From: Holland, Gargi - Communities <Gargi.Holland@Oxfordshire.gov.uk>
Sent: 01 October 2020 15:17
To: Emma Whitley
Cc: Planning; Cllr Arash Ali Fatemian
Subject: 20/02280/F - St Tropez, East Street, Bodicote, OX15 4EB

Planning application: 20/02280/F
Location: St Tropez, East Street, Bodicote, OX15 4EB
Description: Two storey front and rear extensions with single storey infill and formation of new first floor extension over side area of dwelling. Enlargement of vehicle access width in frontage stone boundary wall.
Type: Full Development
Case Officer: Emma Whitley

St. Tropez, East Street, Bodicote, Banbury, Oxfordshire. Proposed Extension & Alterations	
scale : 1 : 50 : 100	I. S. Mills Associates Brookdale, 34 Bucknell Road, Bicester, Oxfordshire, OX26 2DG.
date : August 2020.	tel/fax : 01869 246383.
sheet size : A1	
drawing : 1933-02	
revisions :

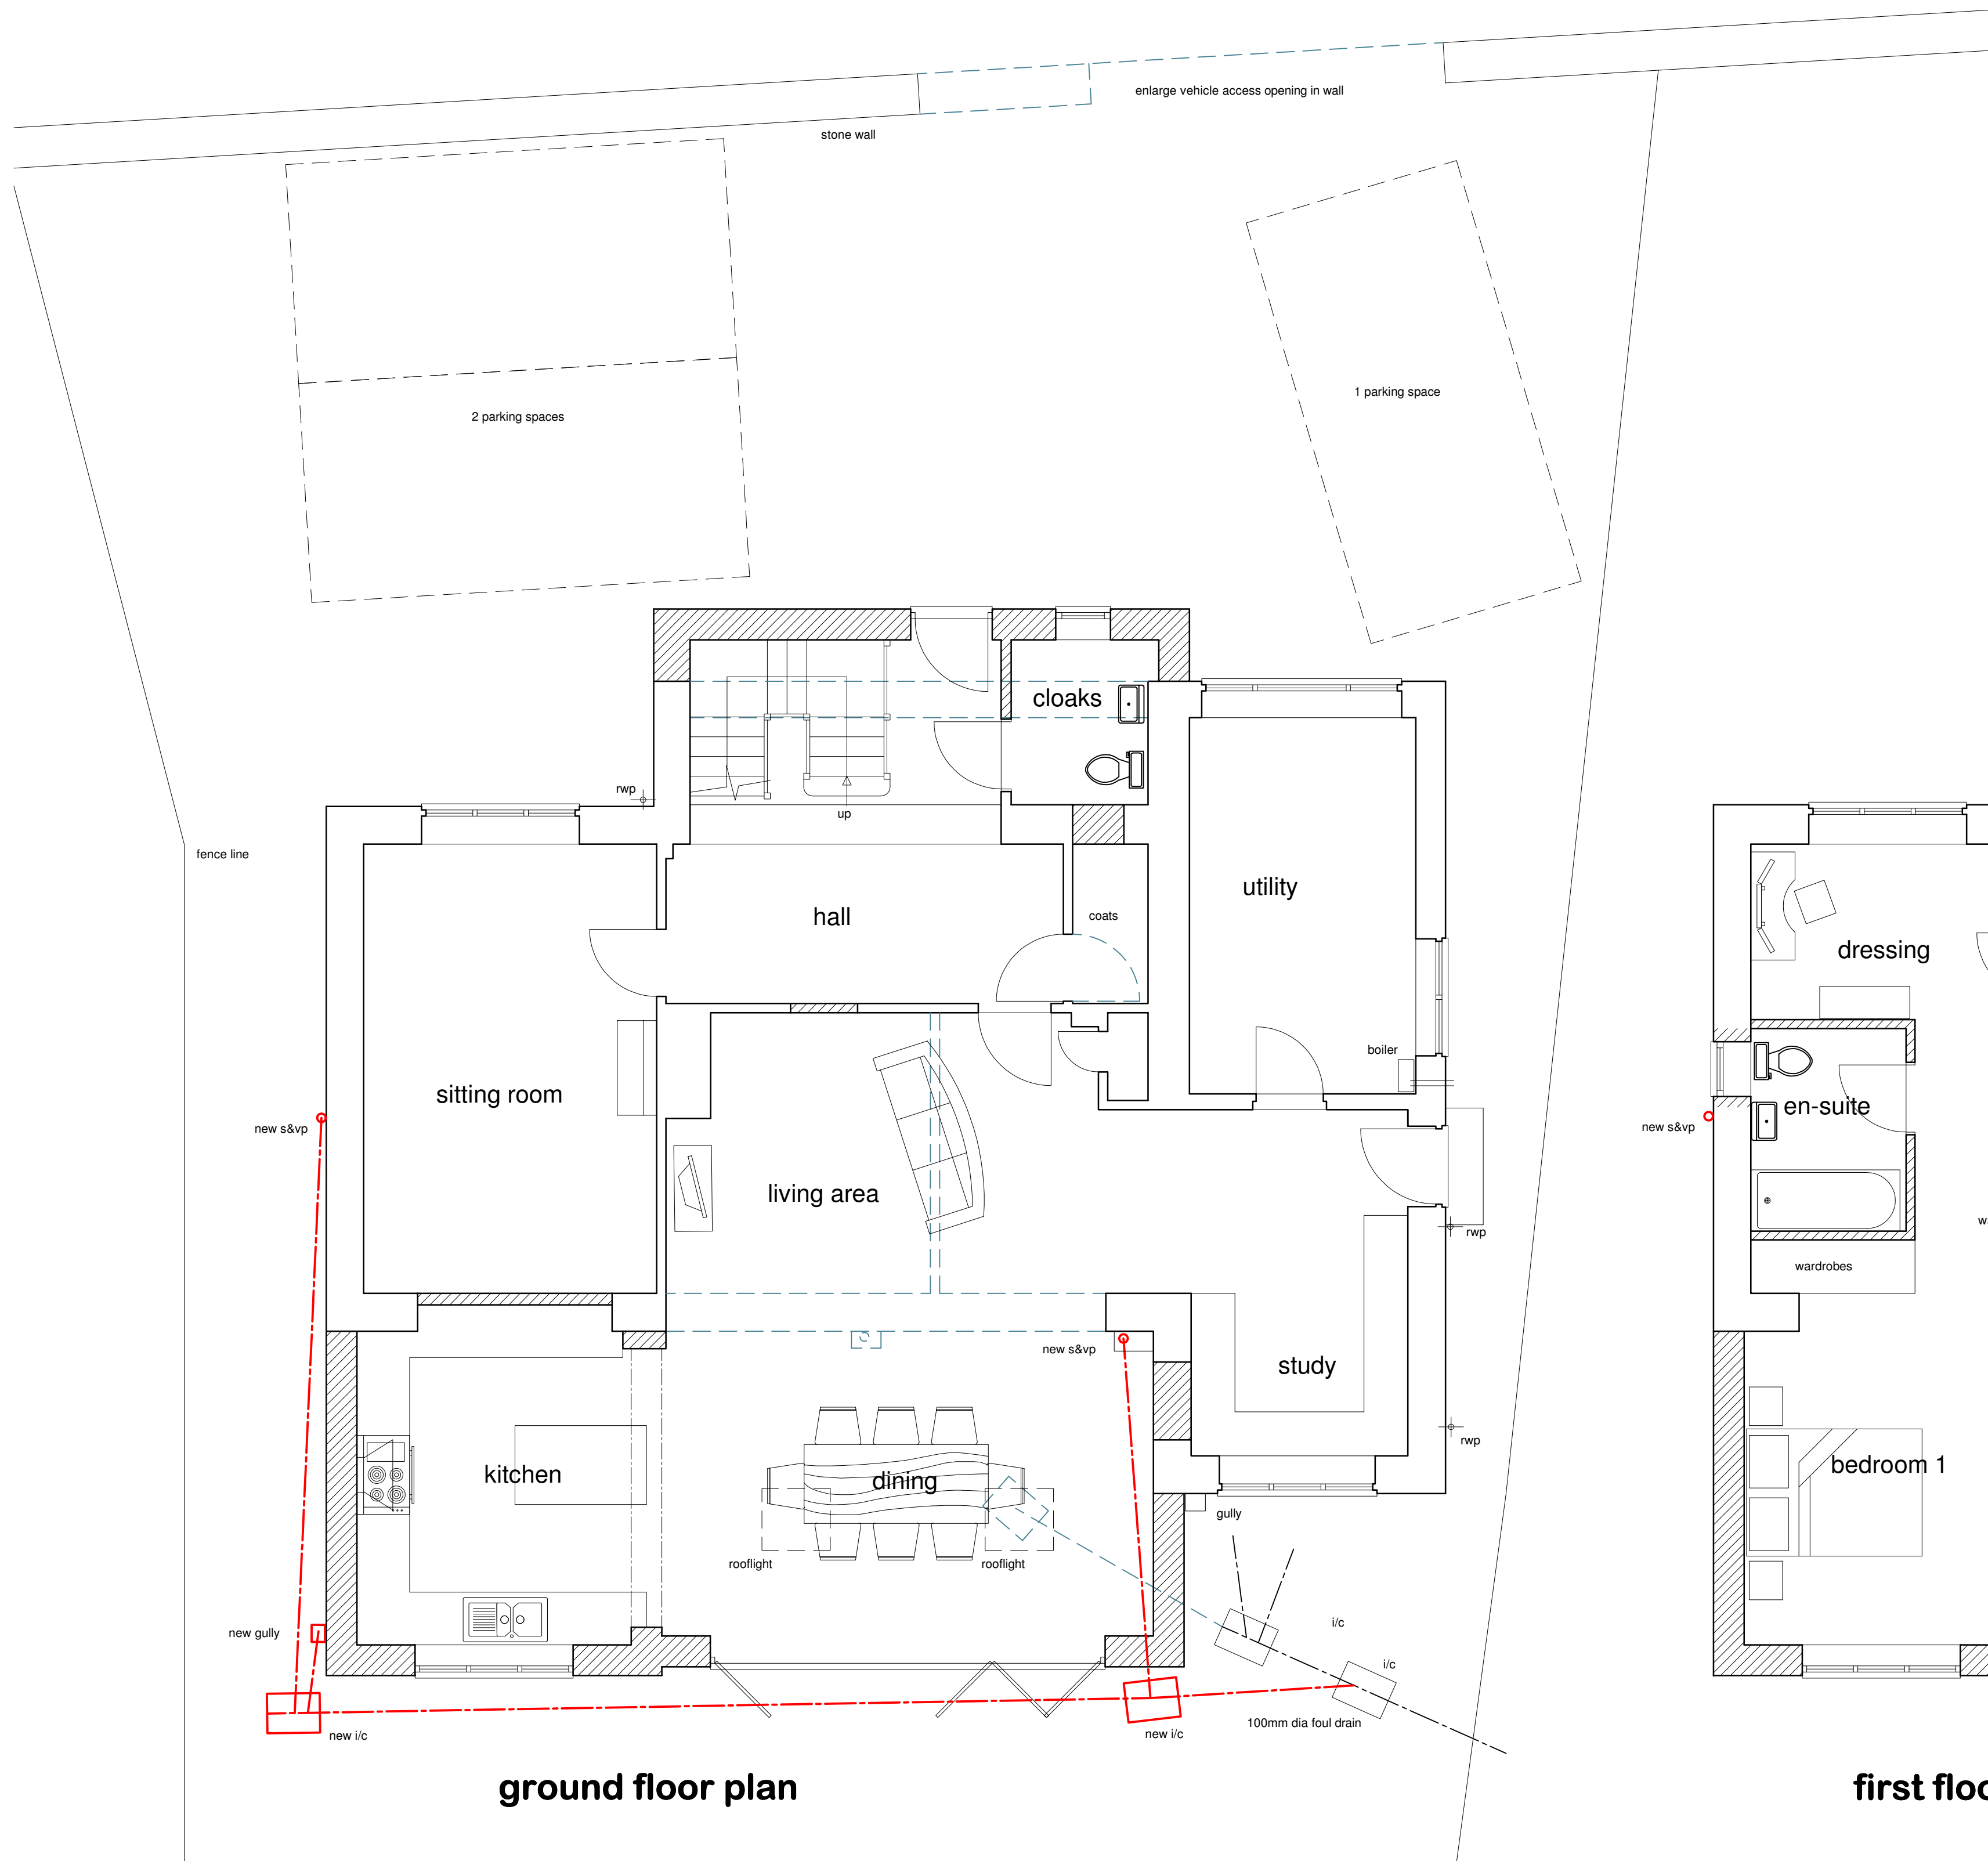
Prior to the first occupation of the development hereby approved, the parking and manoeuvring areas shall be provided in accordance with the plan approved (Drawing no. 1933-02) and shall be constructed from porous materials or provision shall be made to direct run-off water from the hard surface to a permeable or porous area or surface within the curtilage of the site. Thereafter, the parking and manoeuvring area shall be retained in accordance with this condition and shall be unobstructed except for the parking and manoeuvring of vehicles at all times.
